CITY OF ALBUQUERQUE

July 23, 2018

RE: **Juan Tabo Hills Park**
Grading and Drainage Plan for SPBP – Disapproved
Engineer's Stamp Date: 7/16/2018 (M22D017A)

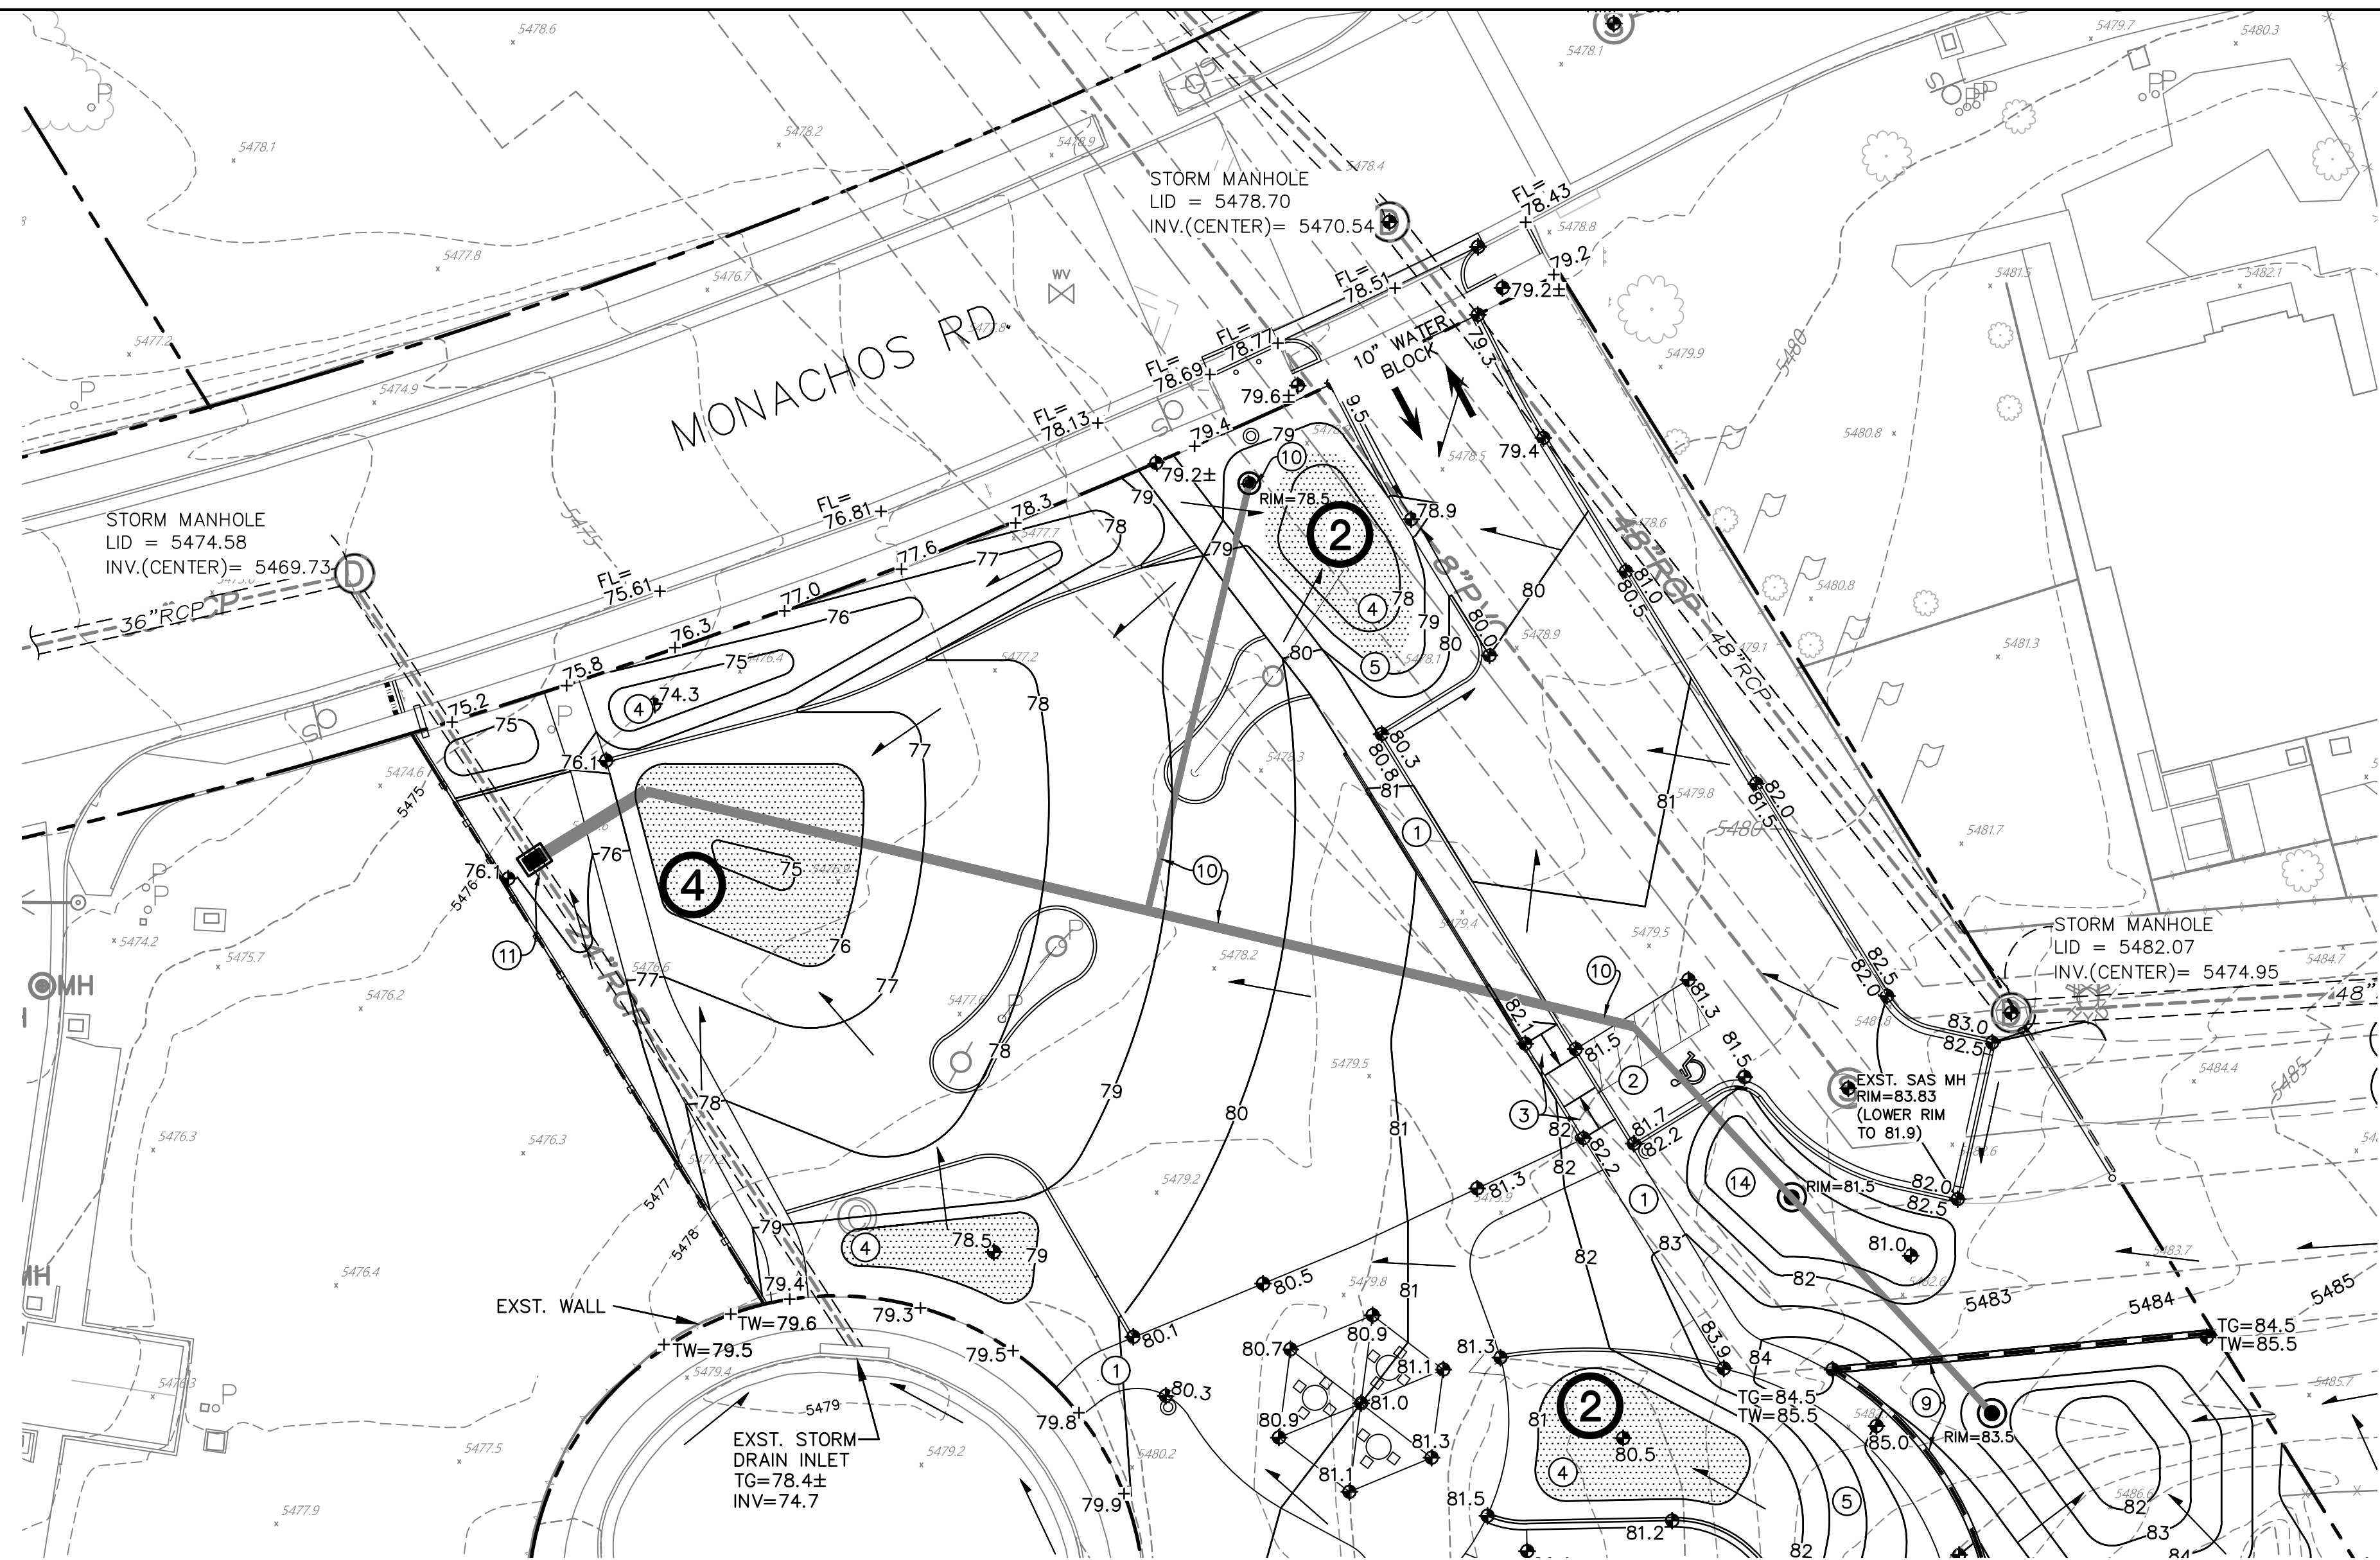
5. Capacity calculations are needed for the swale running down the west side of the park between the Gulf Stream cul-de-sac and Monachos Rd. to insure that drainage does not cross into the private lot west of the park.
